Please add PCD File No. SP21-001

Subject: PCD Comment Legend
Page Index: 1
Date: 3/18/2021 3:31:46 PM
Author: dsdrice
Color: 
Layer:
Space:
Page Label: 1

Subject: EPC ENG Review
Page Index: 1
Date: 3/18/2021 3:31:53 PM
Author: dsdrice
Color: 
Layer:
Space:
Page Label: 1

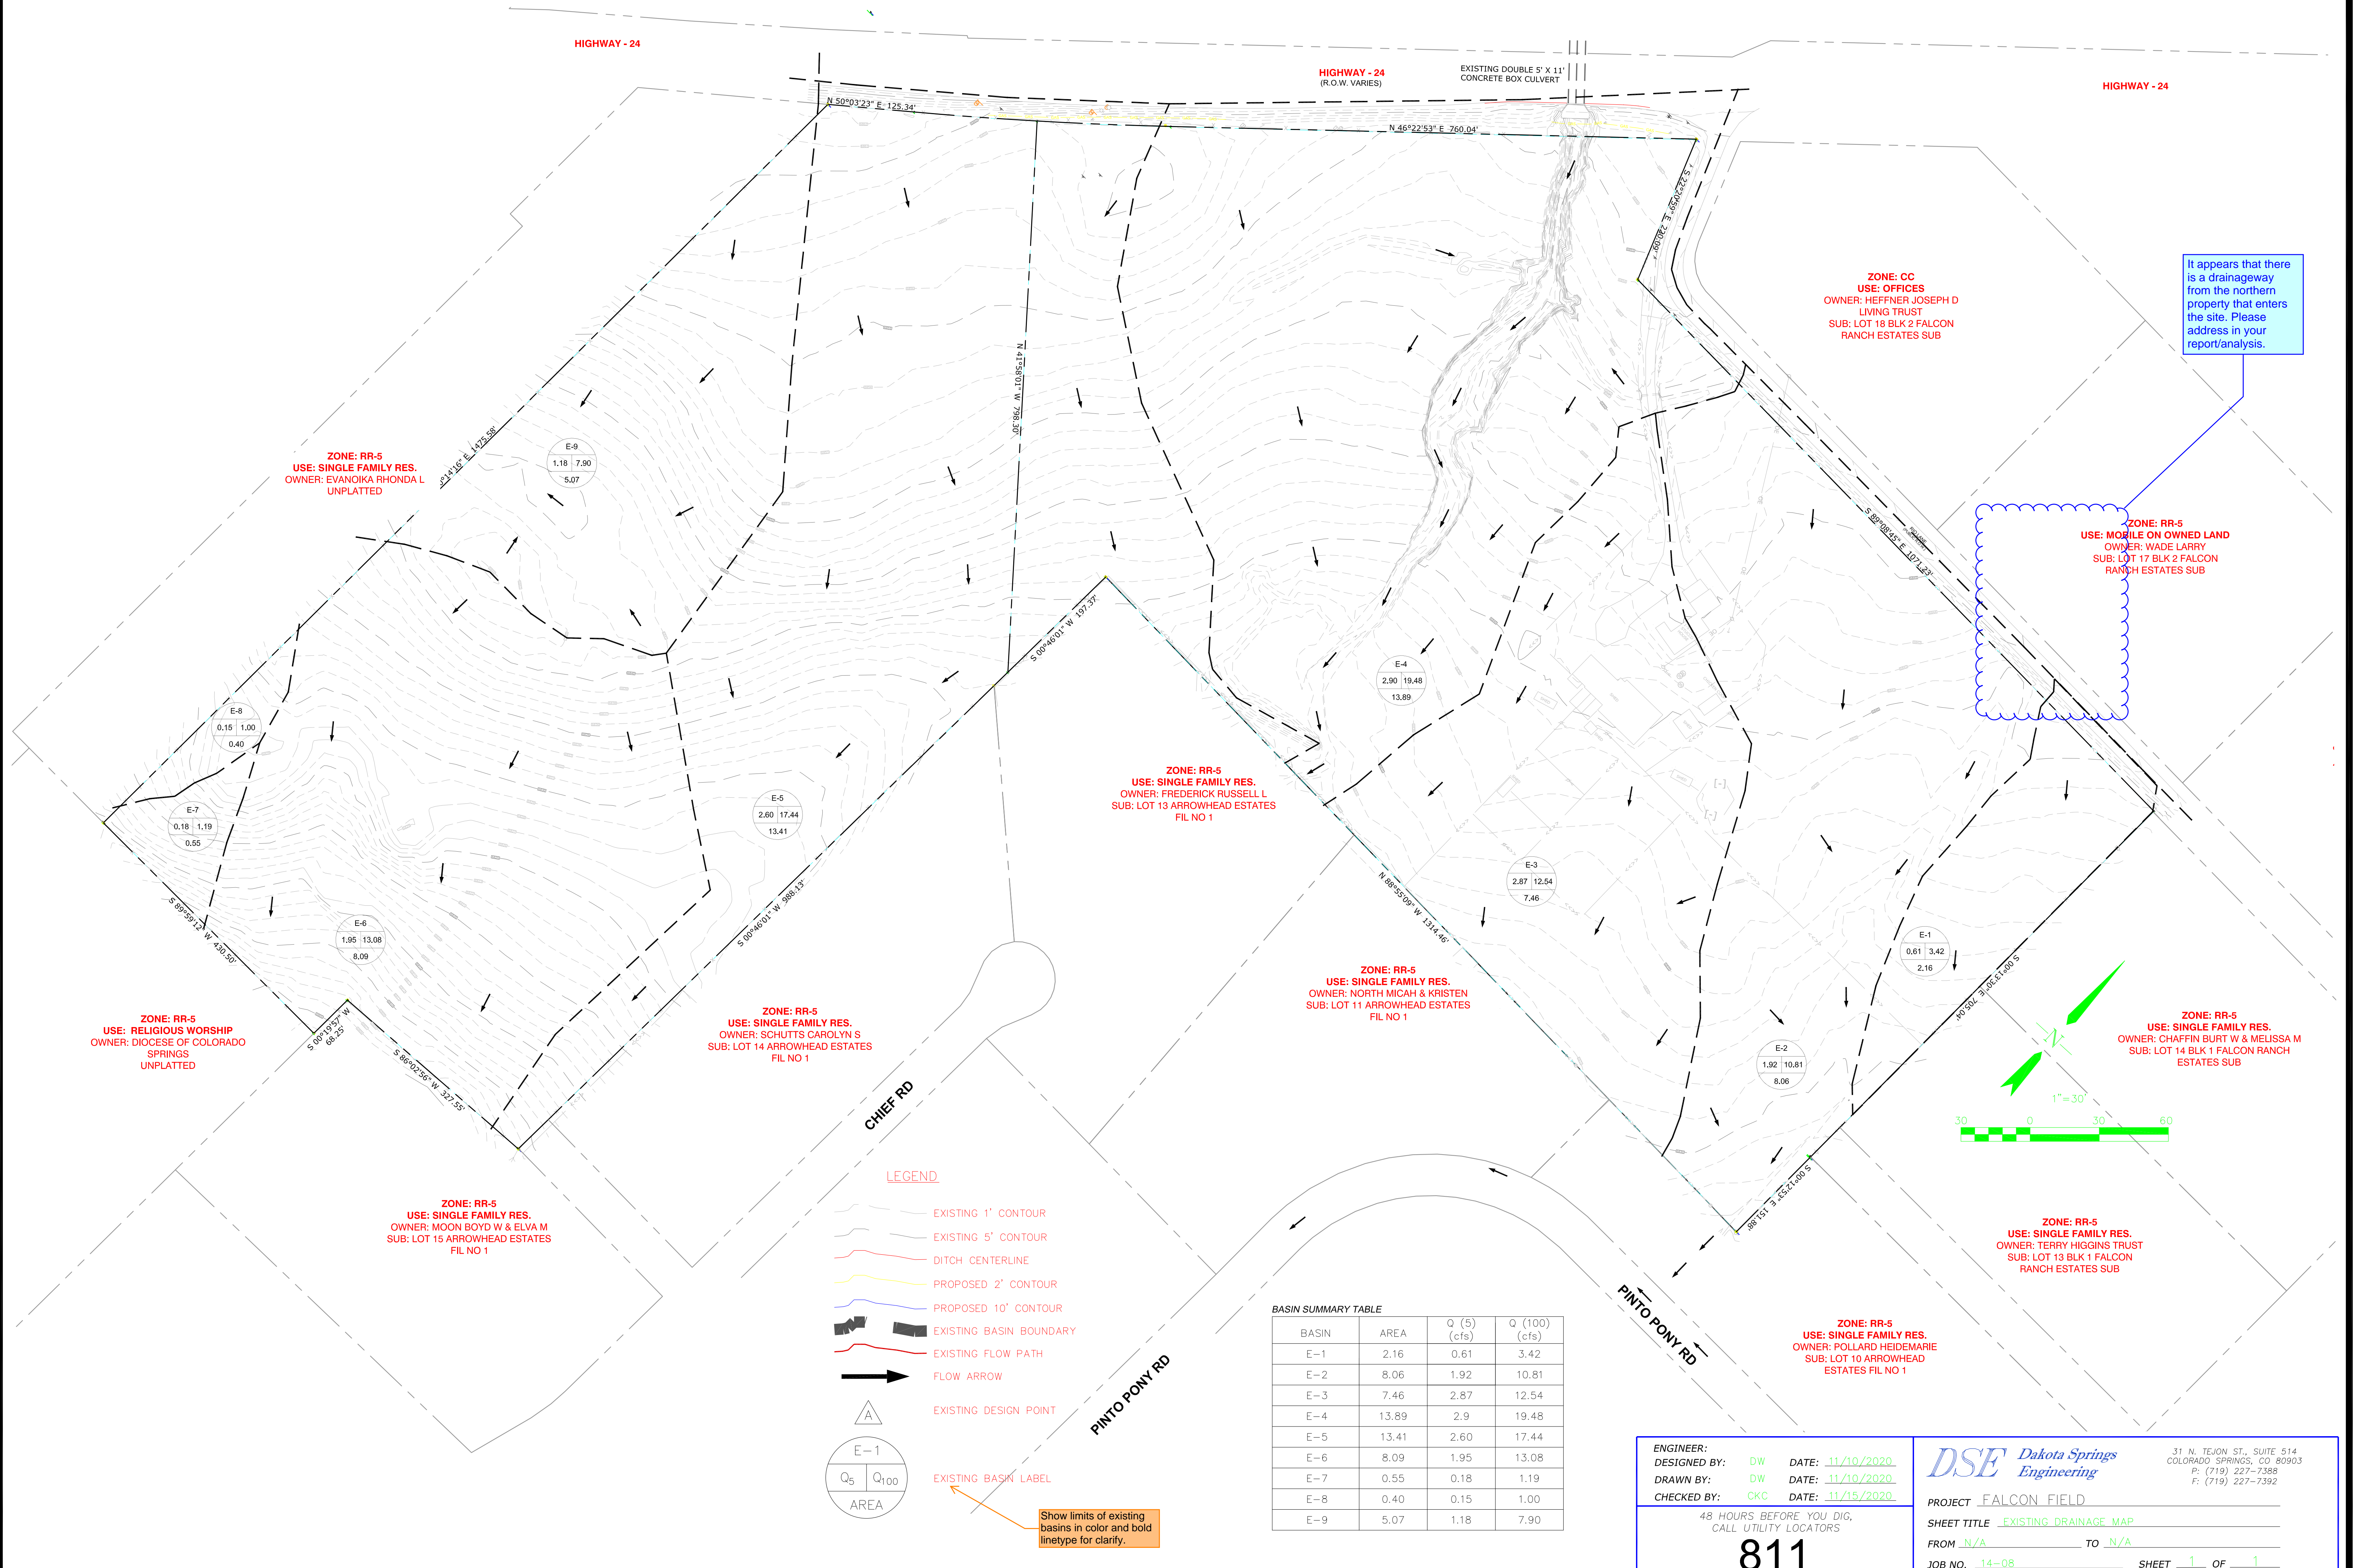
Please identify the design points on the existing drainage plan

Show limits of existing basins in color and bold linetype for clarity.

It appears that there is a drainageway from the northern property that enters the site. Please address in your report/analysis.

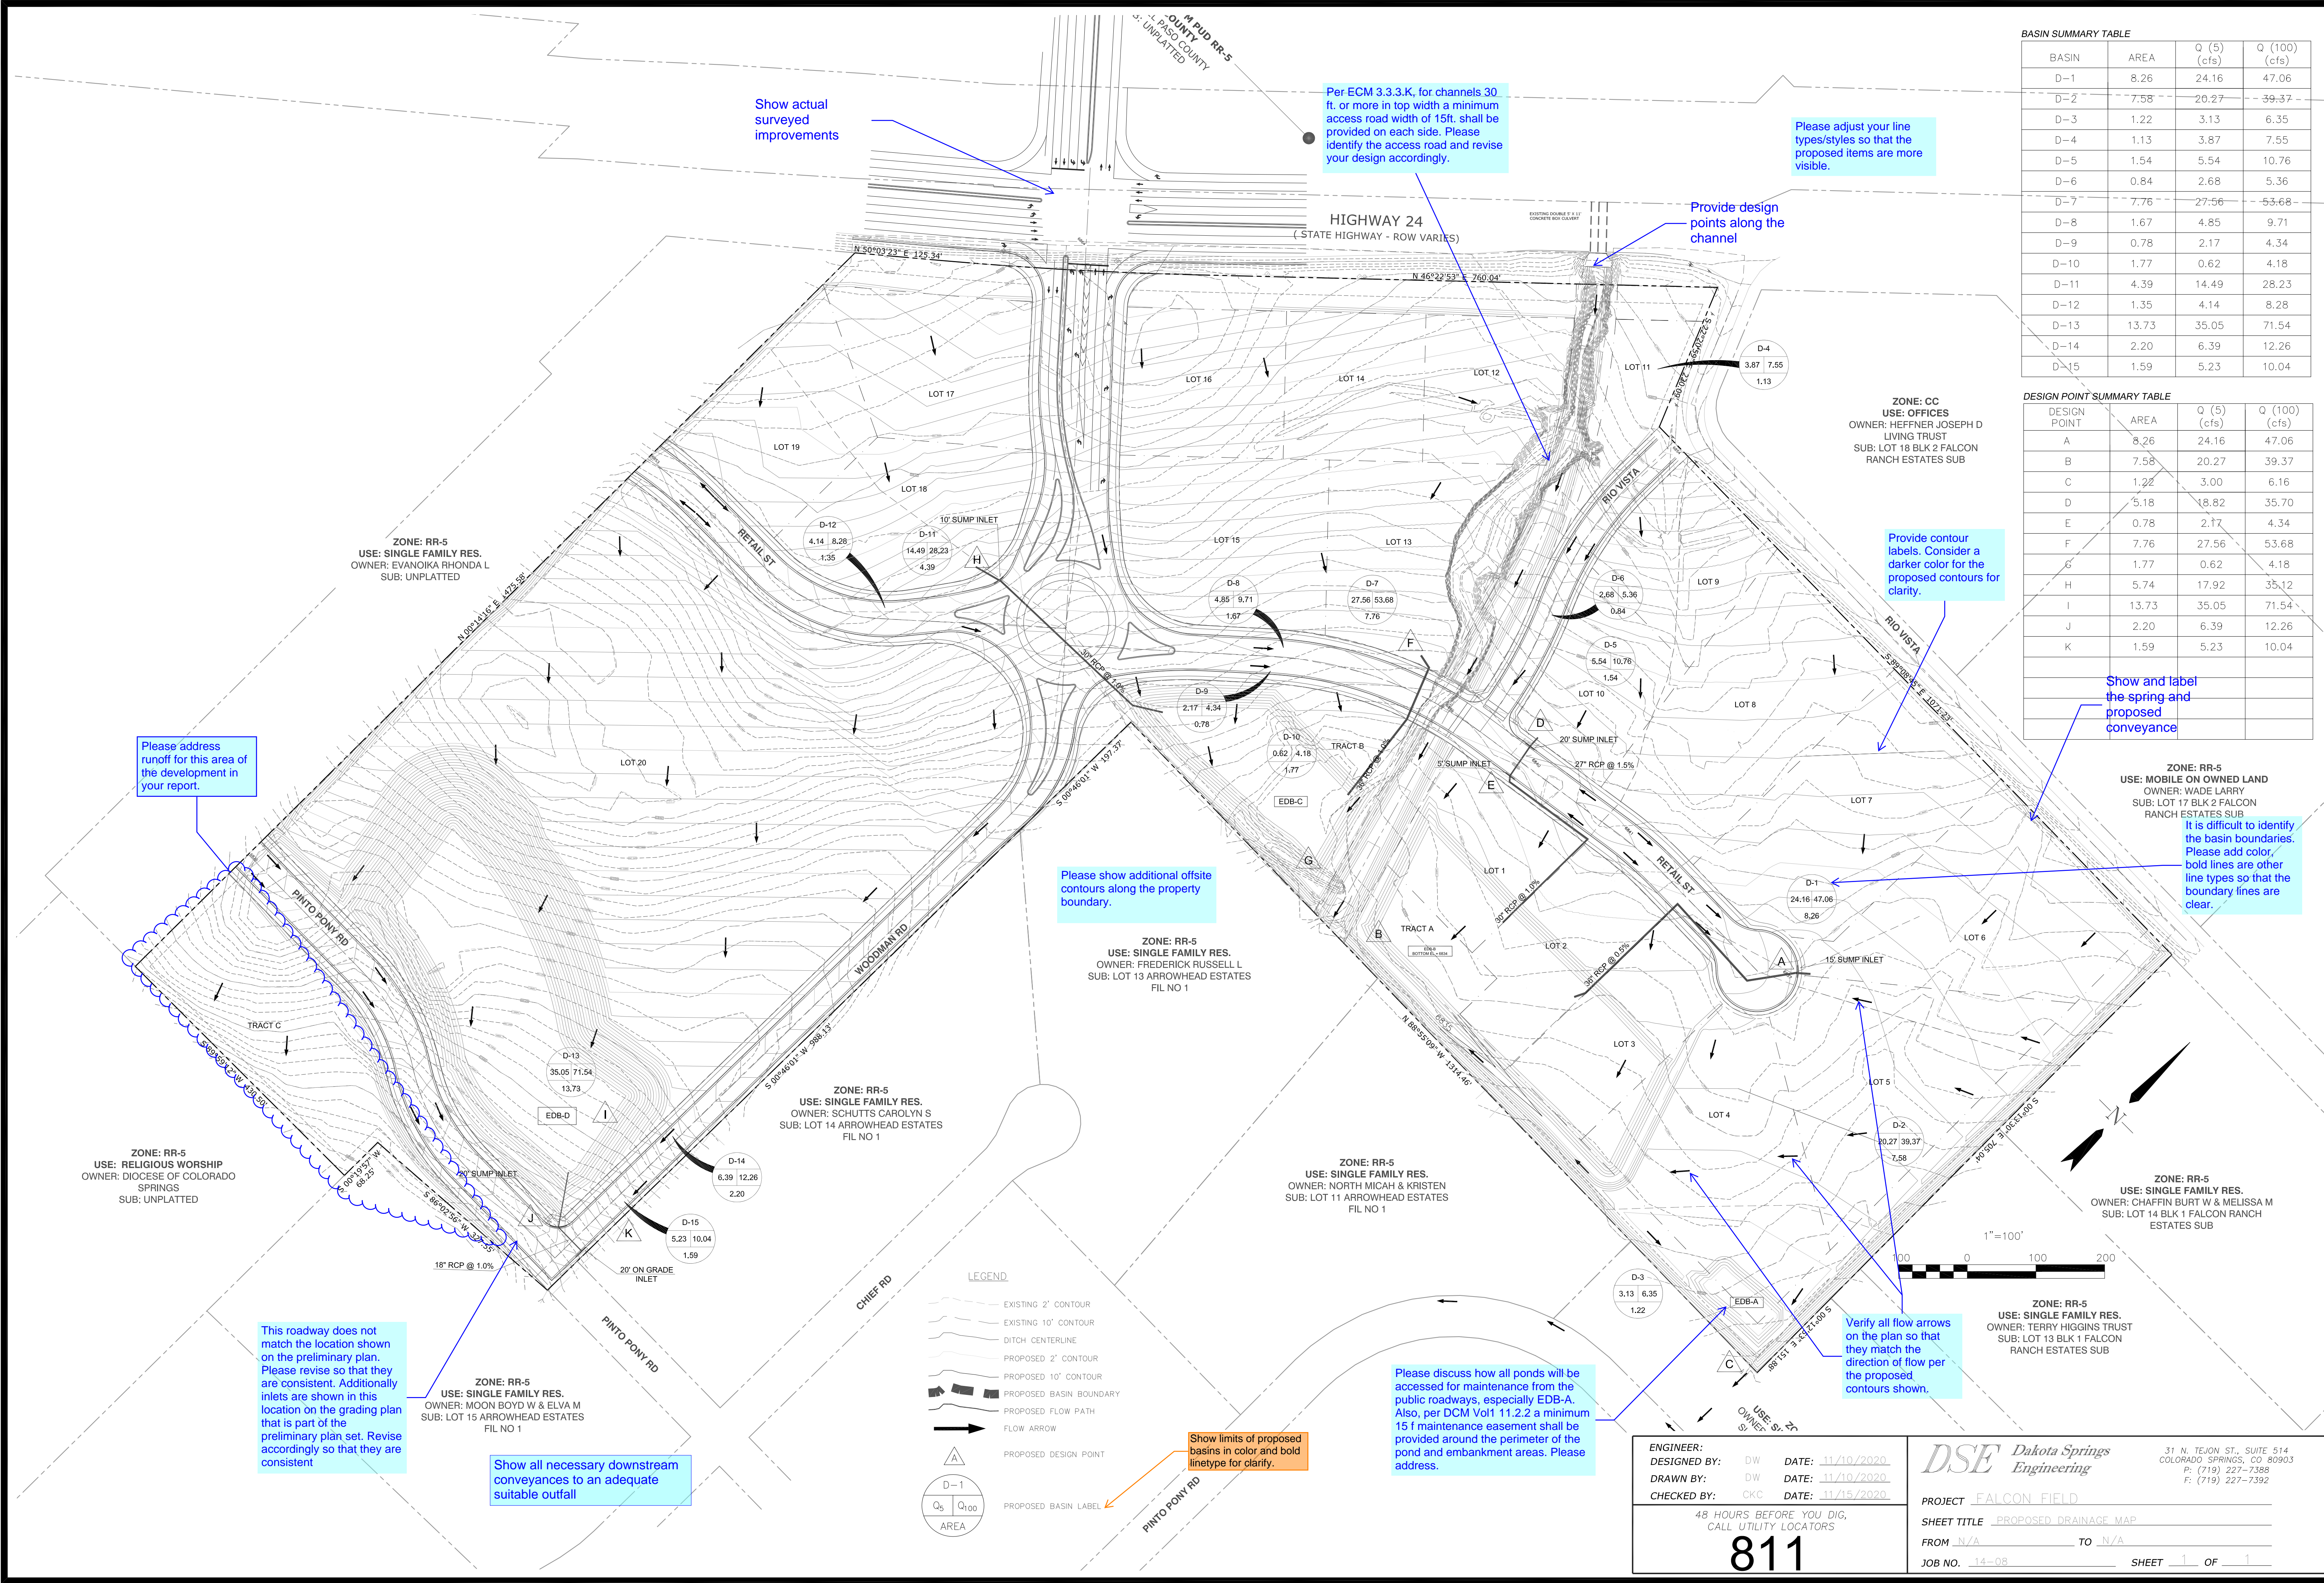
Show limits of proposed basins in color and bold linetype for clarify.

Please show additional offsite contours along the property boundary.

Please adjust your line types/styles so that the proposed items are more visible.

Please address runoff for this area of the development in your report.

Please discuss how all ponds will be accessed for maintenance from the public roadways, especially EDB-A. Also, per DCM Vol1 11.2.2 a minimum 15 f maintenance easement shall be provided around the perimeter of the pond and embankment areas. Please address.

Per ECM 3.3.3.K, for channels 30 ft. or more in top width a minimum access road width of 15ft. shall be provided on each side. Please identify the access road and revise your design accordingly.

Show and label the spring and proposed conveyance

Show actual surveyed improvements

Provide design points along the channel

This roadway does not match the location shown on the preliminary plan. Please revise so that they are consistent. Additionally inlets are shown in this location on the grading plan that is part of the preliminary plan set. Revise accordingly so that they are consistent

Show all necessary downstream conveyances to an adequate suitable outfall

It is difficult to identify the basin boundaries.
Please add color, bold lines are other line types so
that the boundary lines are clear.

Provide contour labels. Consider a darker color for
the proposed contours for clarity.

Verify all flow arrows on the plan so that they
match the direction of flow per the proposed
contours shown.
